26/02/2021

**Tallowong Station Precinct South Stage 2 (SSD-10425) and (SSD-9063-MOD-1)
Request for Additional Information**

CONFERTA AVENUE DETAIL PLAN

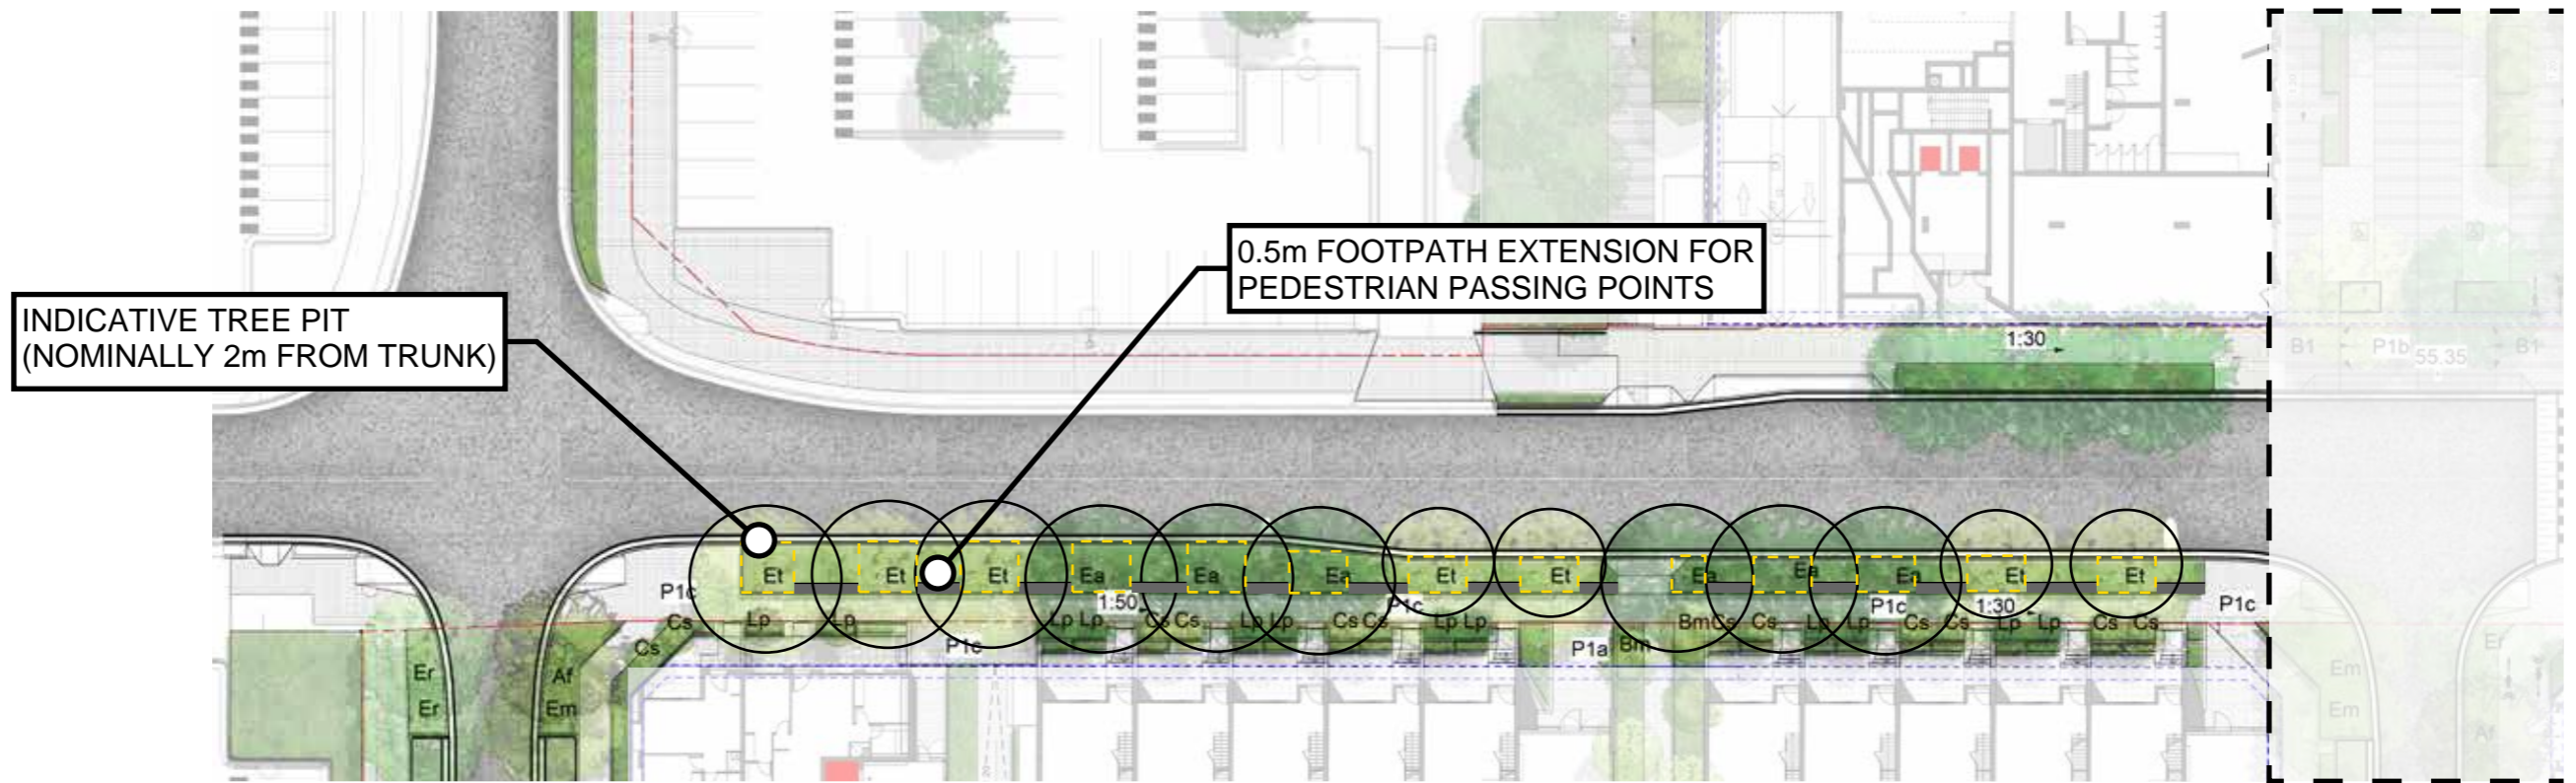
- resolve the outstanding issues raised in the submission by TfNSW relating to:
 - owner's consent/land acquisition for the proposed stormwater works at the corner of Schofields Road and Cudgegong Road
 - the width of footpaths on Conferta Avenue
- submit an updated Flood Impact Assessment addressing discrepancies in flood levels and response to flood events as identified in the submission from the DPIE Biodiversity and Conservation Division
- assess the potential impacts of the proposal on the Rouse Hill Switch Station as required by Endeavour Energy
- provide terms and details on securing public access, operation and maintenance for the proposed public open space to be covered by a separate voluntary planning agreement
- submit revised stormwater plans and supporting information in response to Council's submission and as agreed at your meeting with Council on 18 February 2021.
